Ref: ck220718 - rfi response

Project **Alterations and Additions to President Private Hospital (SSD – 10320)**
At: 369-381 President Ave 61-65 Hotham Rd, 2-4 Bidural, Kirrawee
Client Macquarie Health Corporation
Project Ref: MACHEALTH-06

RESPONSE TO REQUEST FOR INFORMATION

PMF CRITICAL STORM DURATION
EXISTING CONDITION
WATER LEVEL (mAHD) & WATER DEPTH (m)

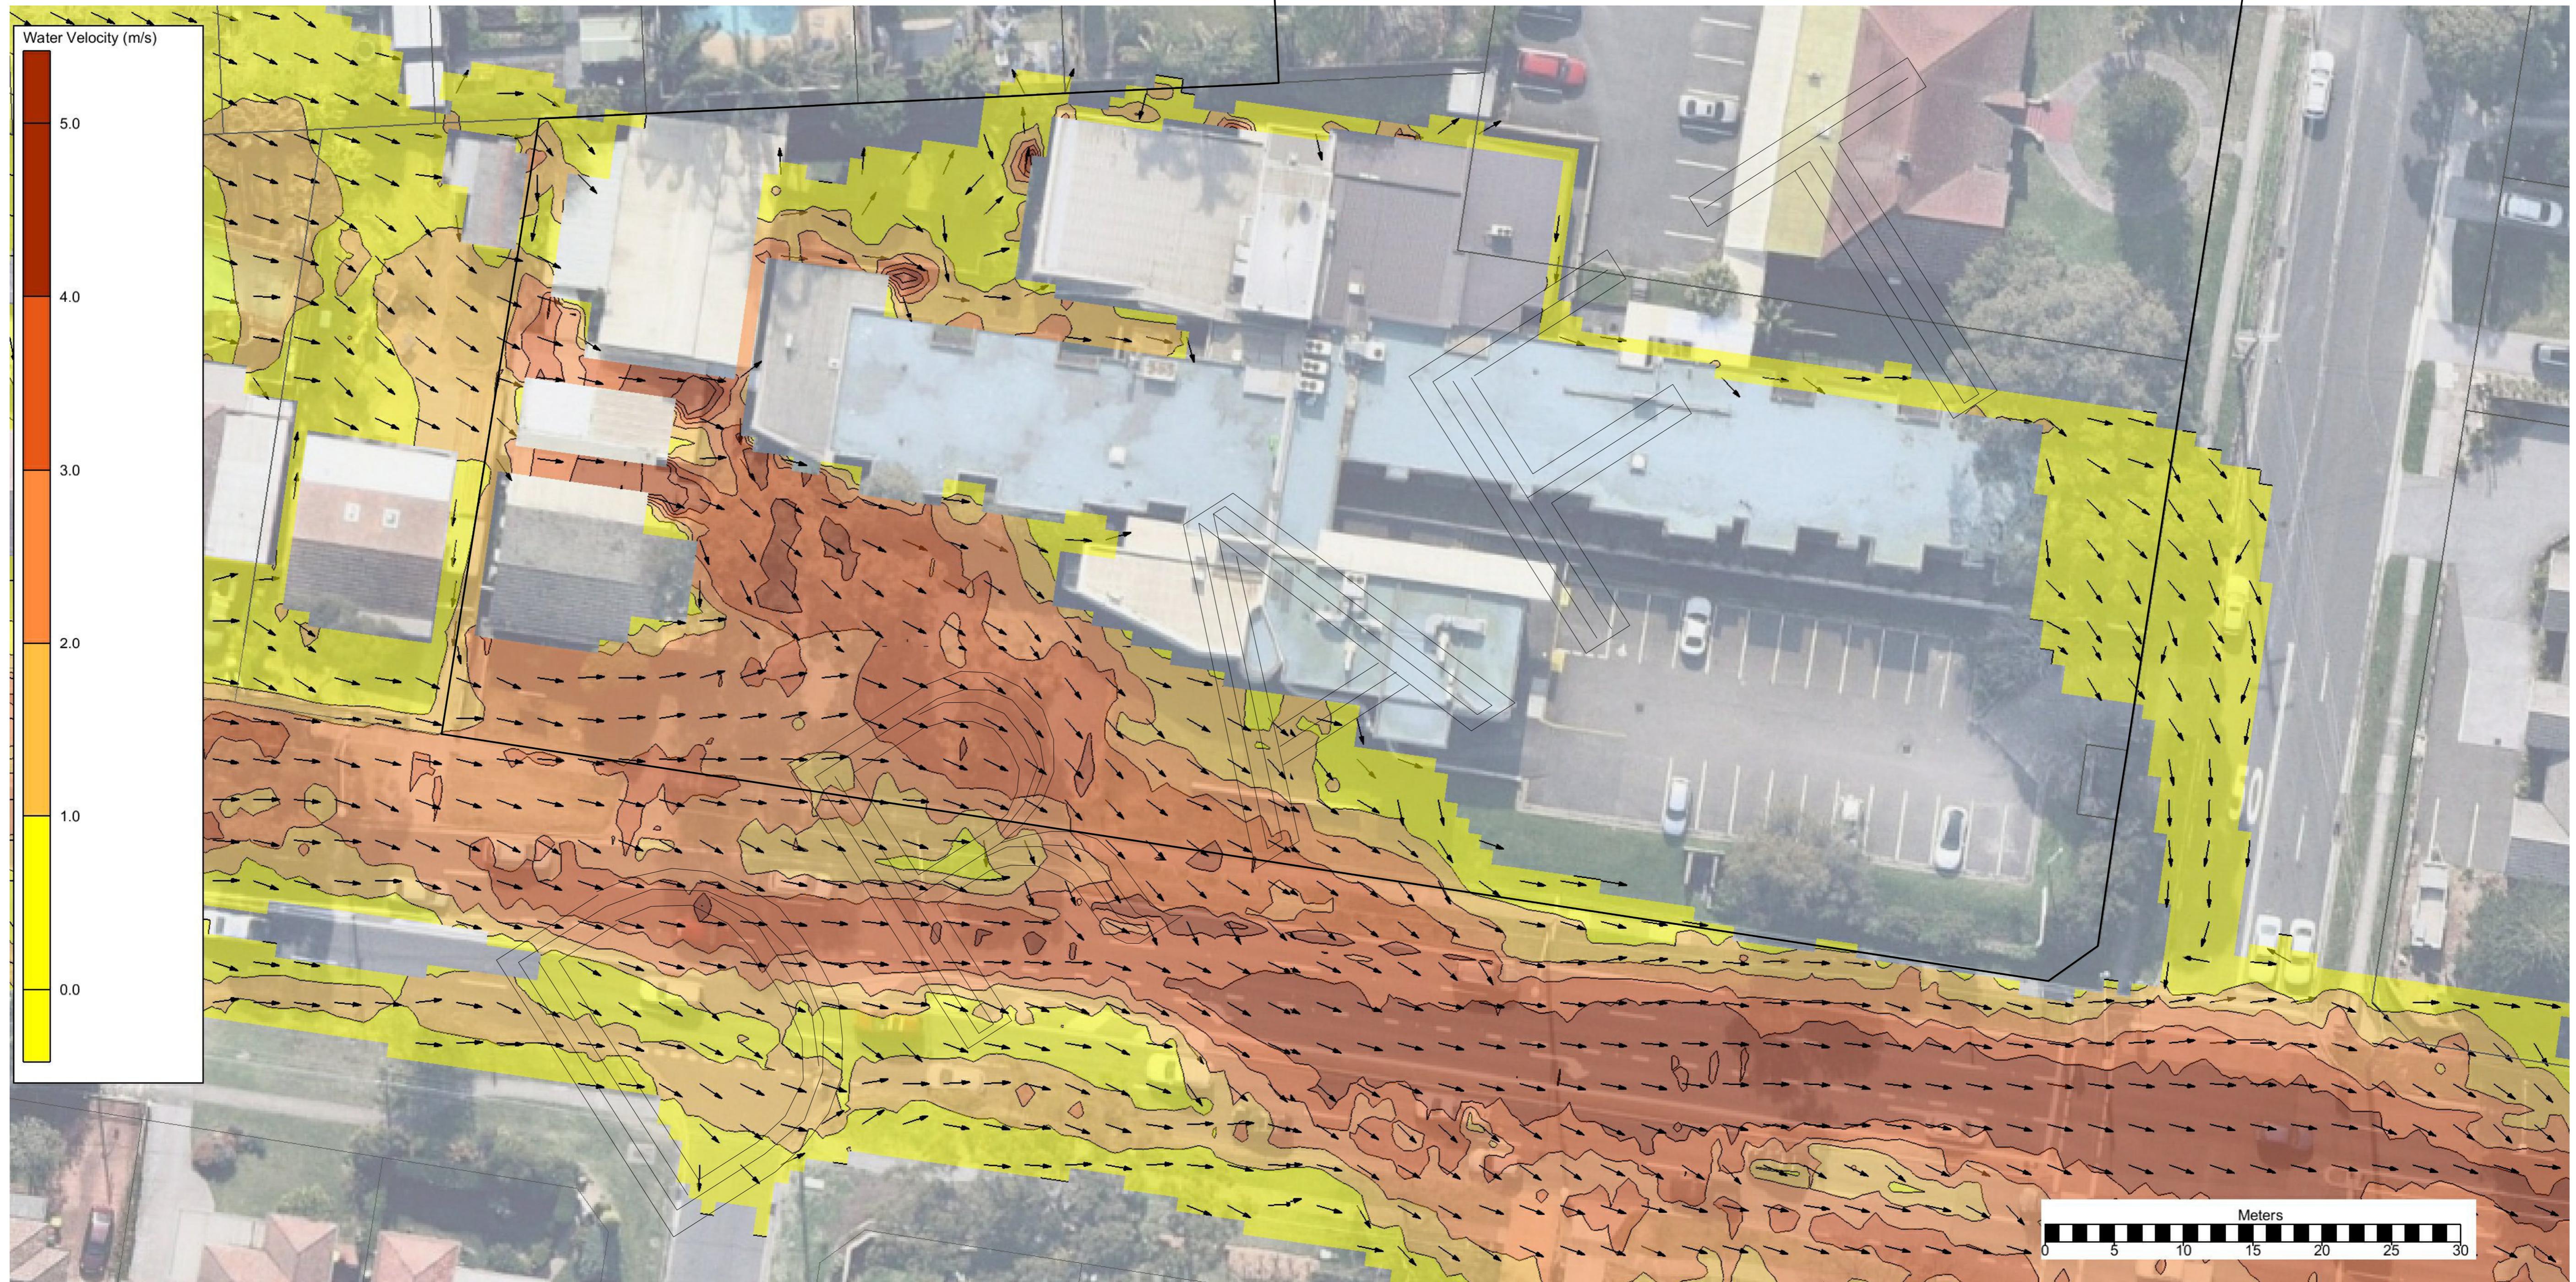
2.	As per the Departments previous request, significant flood depths are noted along the northwestern property boundary in the PMF which are higher than the building floor levels presented in Figure 3 of the MA (Feb 2022) report. Further information is required to demonstrate how floor level compliance is to be achieved for existing facilities located in this area of the site through increasing floor levels above the PMF level or, PMF levels reduced below the FFL.	Refer to the statement provided by Martens Consulting Engineers dated 18 July 2022. This statement is accompanied by drawing of the Proposed Overland Flow Path for the area of concern. This drawing was produced by Imagescape Design Studios and is attached to the end of the statement provided by Martens.
